VN222468 – Proposed Residential Development, Primrose Lane, Liversedge

Transport Assessment Addendum Note

Following submission of the planning application to Kirklees Council (KC) (application ref: 2023/91116) in April 2023, and a supporting Transport Assessment (TA) dated March 2023 prepared by Vectos, comments have been provided by KC Highways Department. A copy of the KC Highways comments is provided at **Appendix A** to this Note, and further information is requested by Highways to assist in their determination of the planning application. A consultation response has been provided from the KC Public Rights of Way (PRoW) Team, and this is also included in Appendix A. The additional information requested relates primarily to the proposed site layout, and this Addendum Transport Note will address these matters with the submission of further supporting information and justification.

Inset 4 - Two Cars Passing on Bend

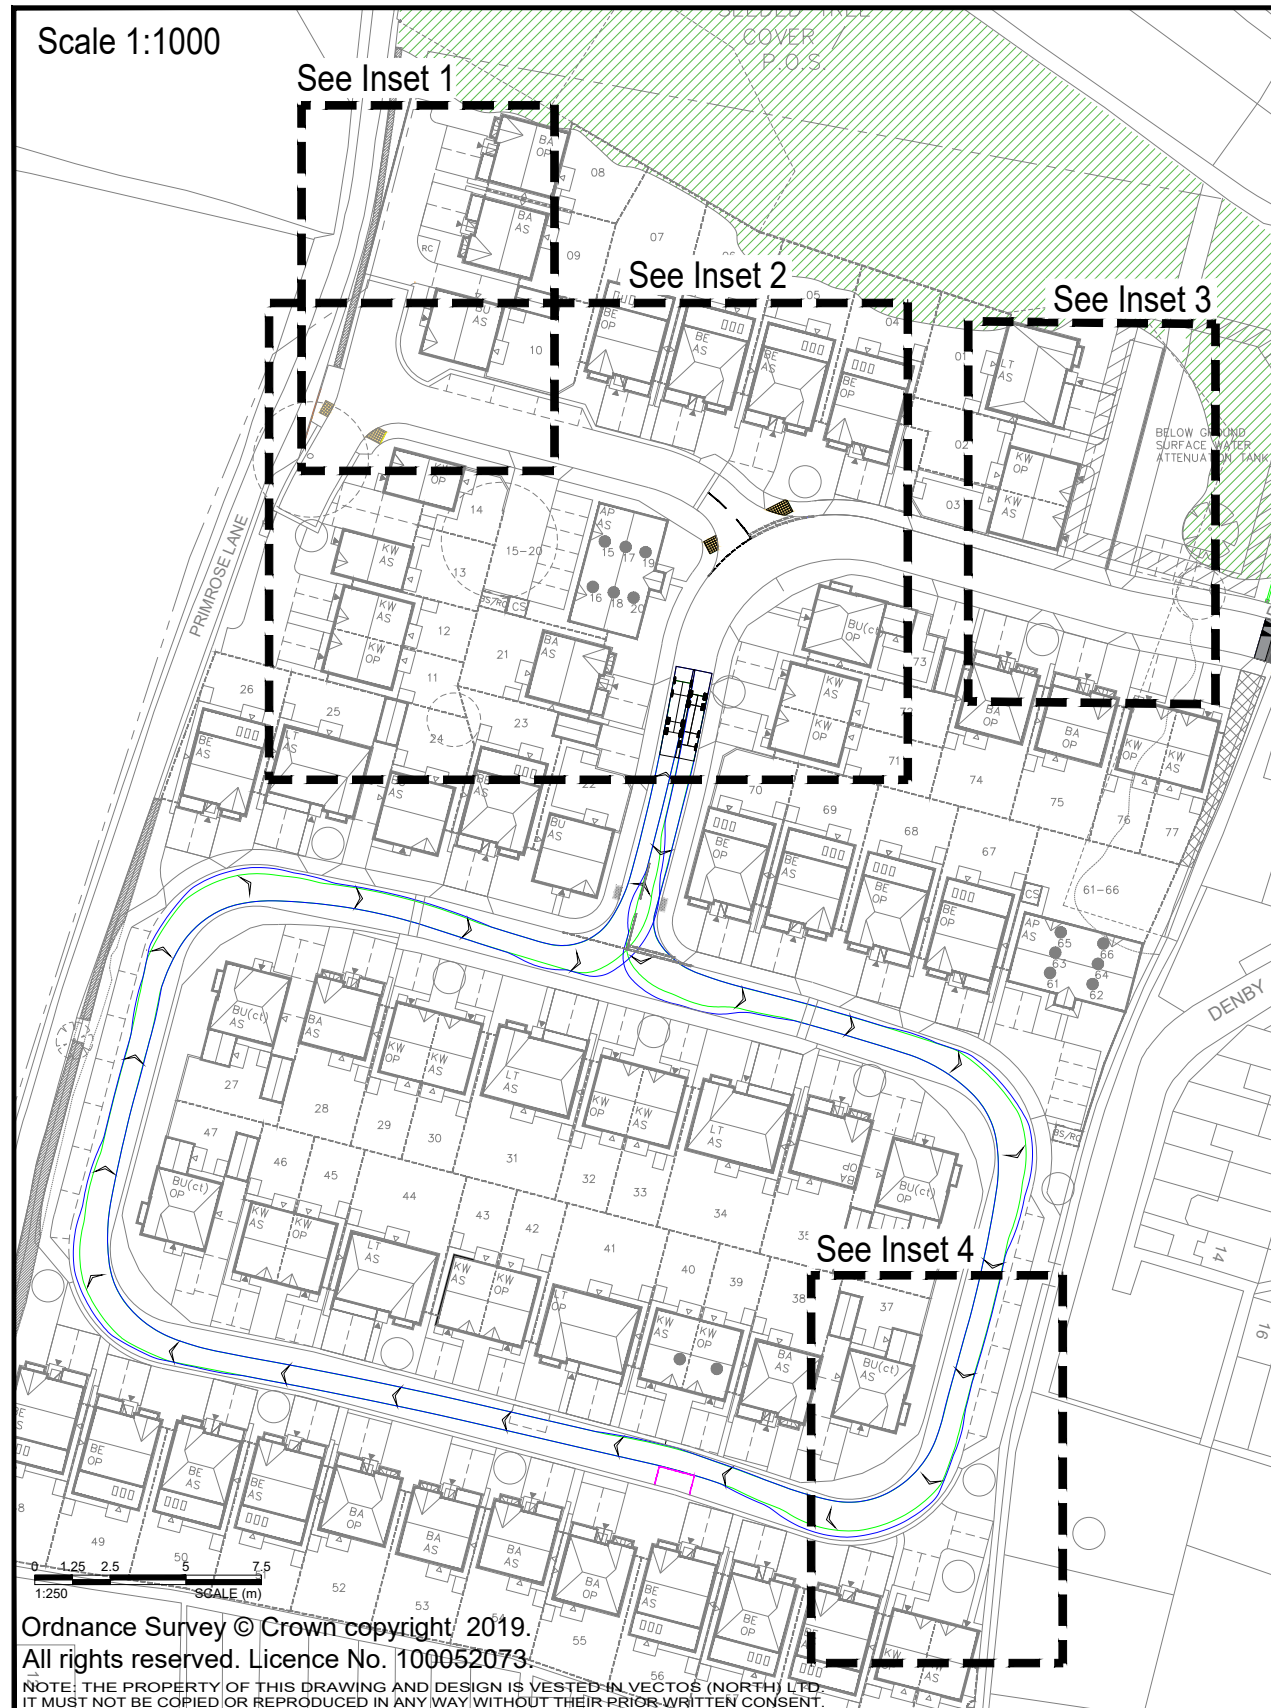
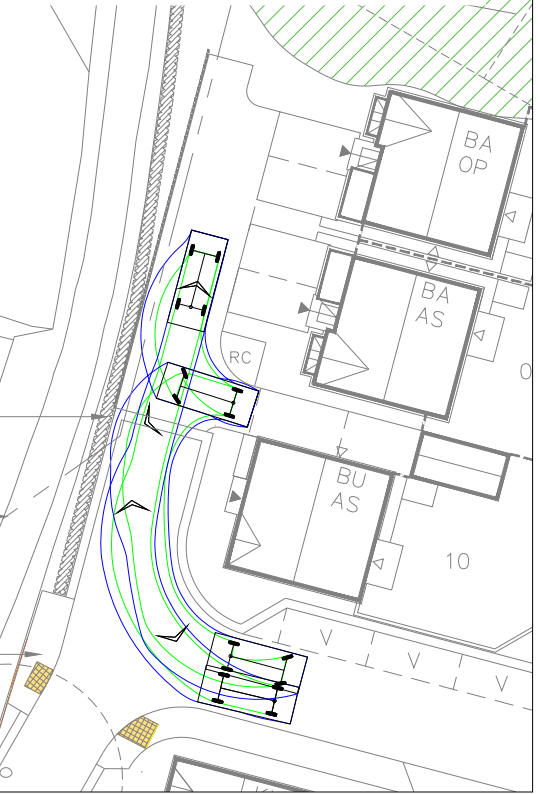
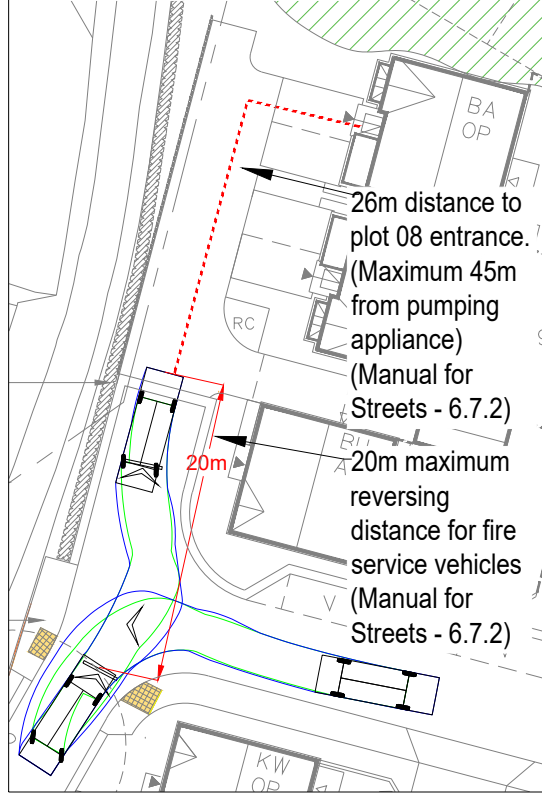
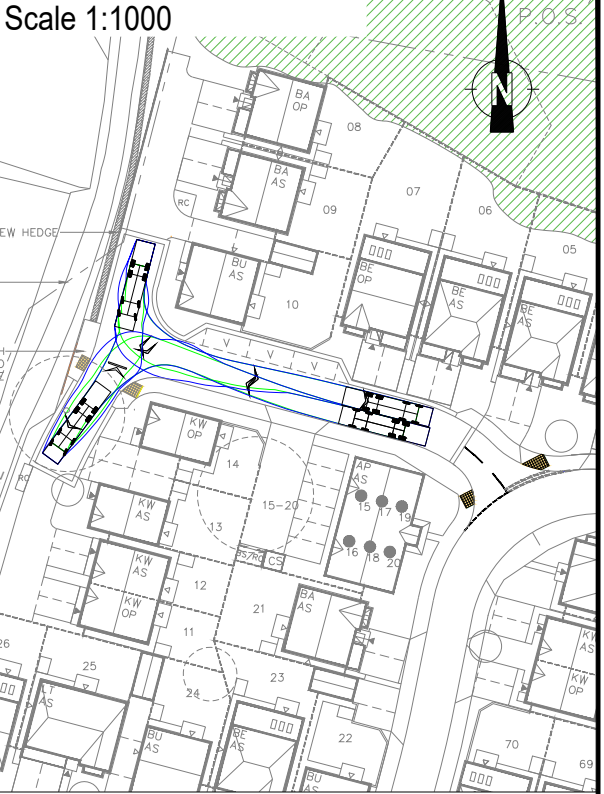
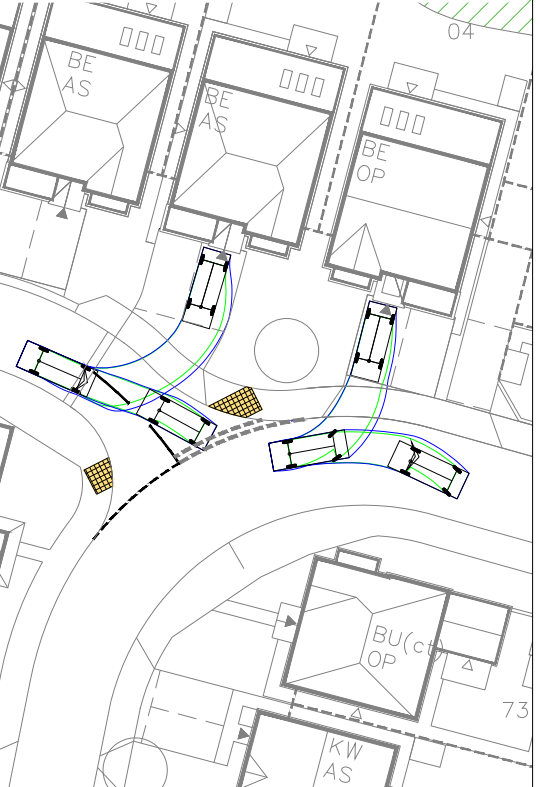
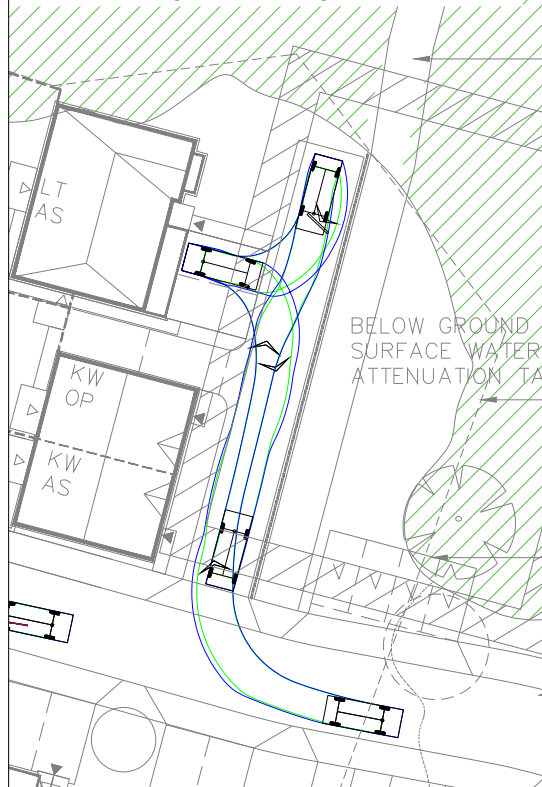
In addition to the above comments from Waste Strategy, it is noted that the cul-de-sac serving Plots 4-9 is in excess of 20m in length. Therefore, in accordance with West Yorkshire Fire and Rescue advice (and the Councils Highway Design SPD), a turning head must be provided. It is also noted that the maximum hose distance of 45m is exceeded for Plots 8-9.

The swept path analysis demonstrates that a refuse vehicle cannot pass a car at the bend adjacent to Plot 63. This bend should be widened to a minimum of 6.1m, and have a centreline radius of at least 20m, to ensure that vehicles can safely pass and obstructions to the refuse vehicle do not occur.

- *Details of new PROW connections, including confirmation of their status (e.g. footways or multi-use routes), as well as improvements to existing PROW;*
- *Updated Swept path analysis of revised layout, including the new turning head that is required for the cul-de-sac serving Plot 4-9; and*
- *Any retaining features affecting the highway (including PROW) need to be clearly identified, and sufficient detail provided to ensure that they are suitable in principle.*

An appropriately designed turning head is now provided on this cul-de-sac, and the proposed access arrangements for a fire tender ensure a maximum hose distance of 45m is not exceeded for Plots 8-9, as shown on **Drawing VN222468-TR100 Rev E**.

The shared surface loop section of carriageway in the southern part of the proposed development site adjacent to plot 63 is not designed to accommodate the passing of a car and refuse vehicle, and this is considered appropriate given that this part of the residential site is proposing a 15mph design speed and it will be very lightly trafficked. The proposed design of the carriageway at this bend facilitates the passing of two cars, as shown on **Drawing VN222468-TR100 Rev E**.

Updated swept path analysis of the revised site layout is shown on **Drawing VN222468-TR100 Rev E**.
